21/03350/TEL and 21/03452/TEL56 – comments from Kirtlington Parish Council

Proposed 5G Telecommunications Installation for H3G at Station Road, Kirtlington

Planning application: 21/03452/TEL56
Location: Street Record, Station Road, Kirtlington
Description: Proposed 15.0m Phase 8 Monopole C/W wrapround Cabinet at base and associated ancillary works.
Type: Telecommunications Prior Approval
Case Officer: John Cosgrove

Title: **210 PROPOSED SITE PLAN**

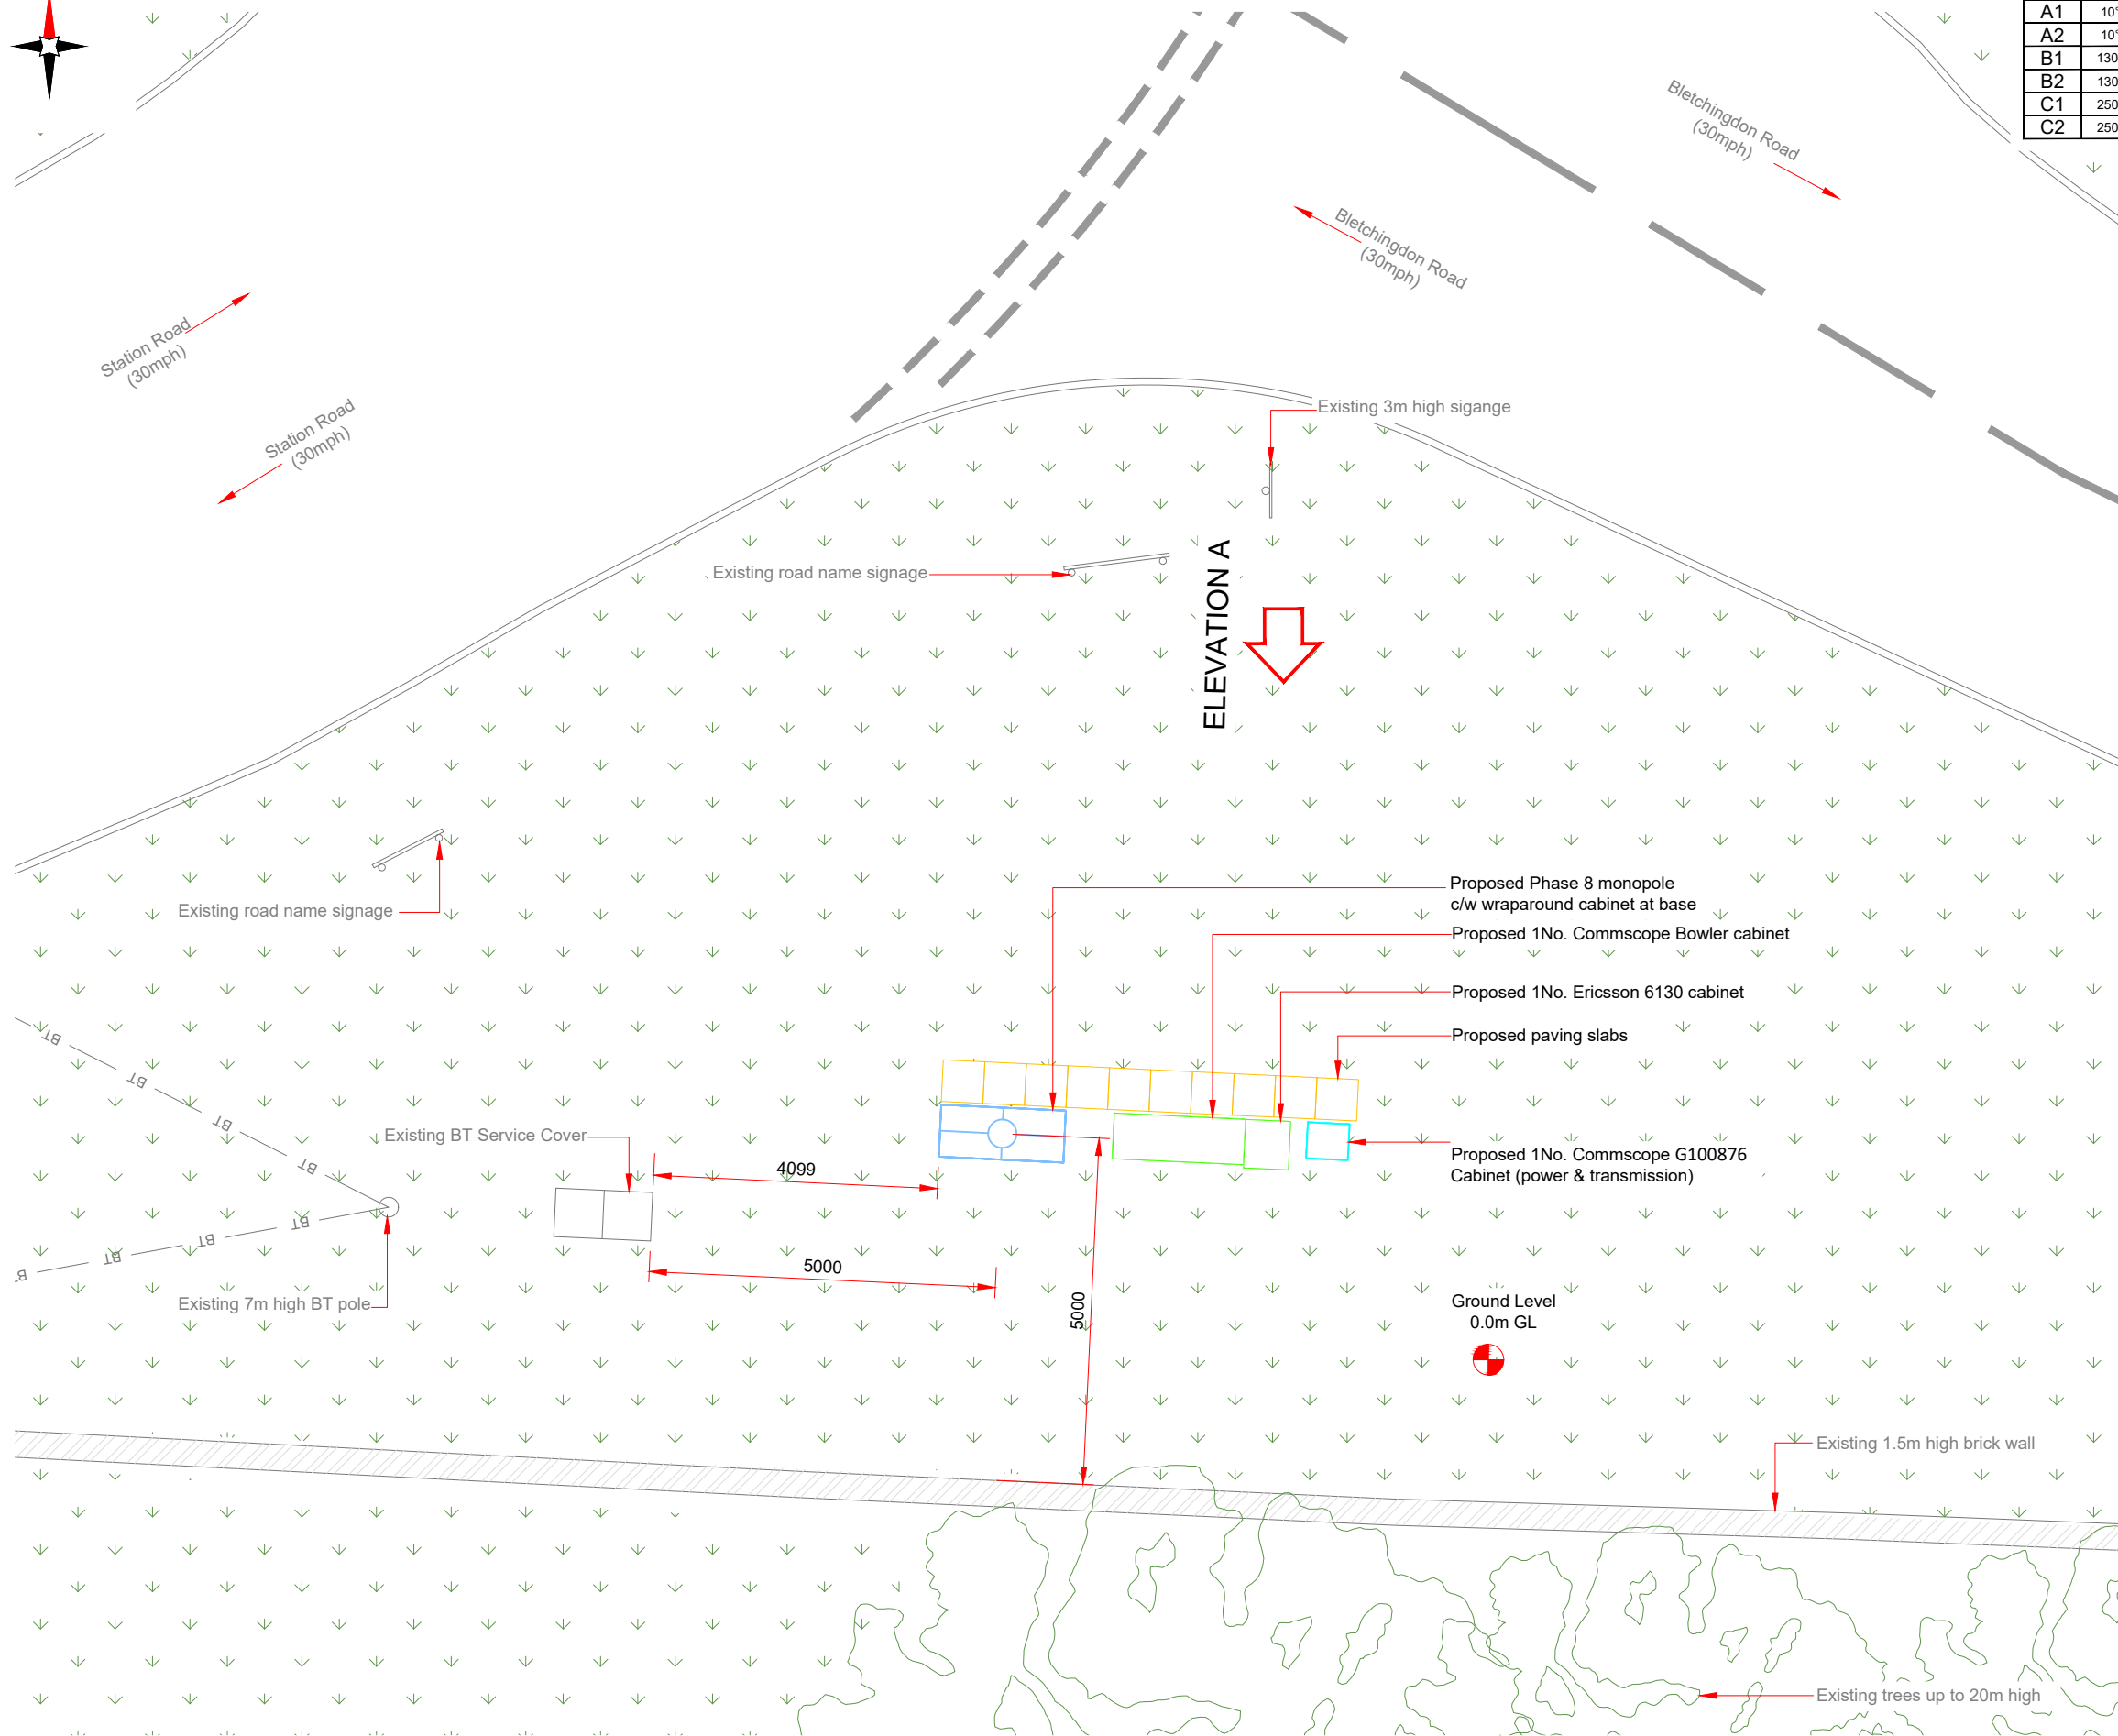
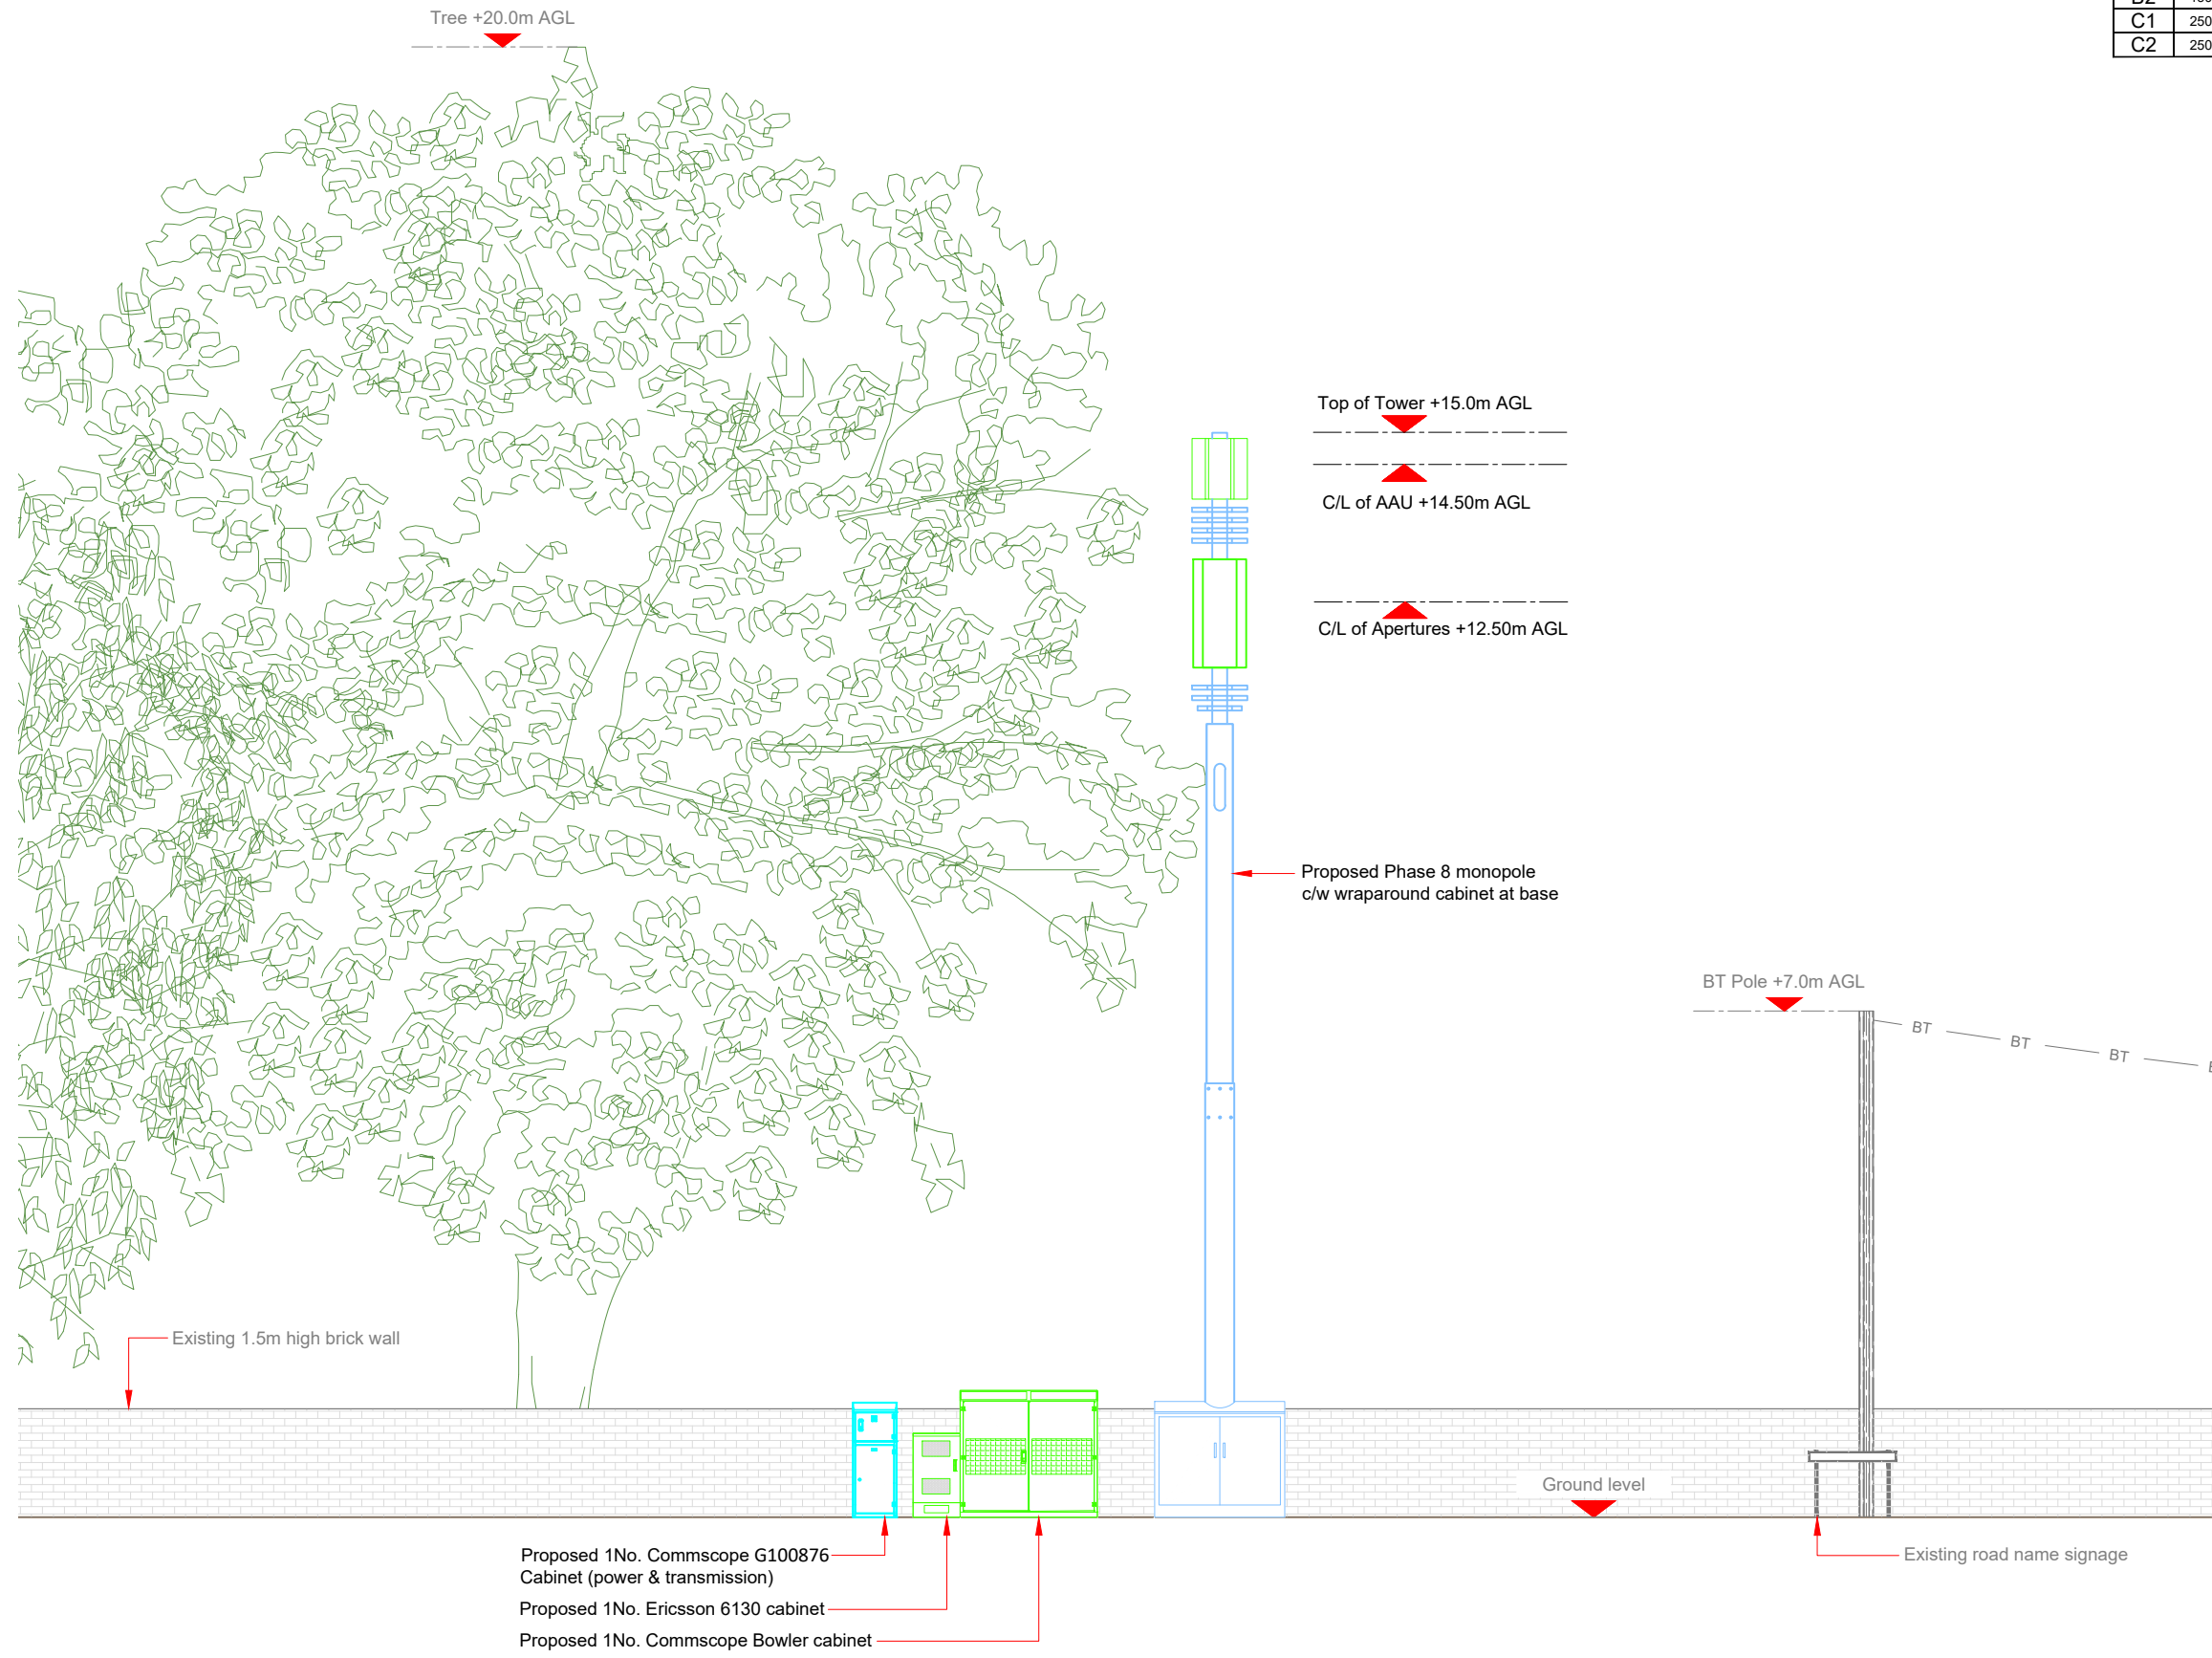
If permission for the proposed mast were granted in the applicant's preferred location, then KPC requests that the cabinets are screened by placing them in a stone walled enclosure, built parallel to the existing retained stone wall. Such mitigation would be supportive of Policy PD5: Building and Site Design of the Mid-Cherwell Neighbourhood Plan. In addition, this verge, up to a few years ago, was the location of a fine mature False Acacia, which unfortunately died, therefore it is requested that a native species tree, of ultimately similar stature, should be replanted in its place, to help mitigate the visual intrusion of the mast on this sensitive location in the village.
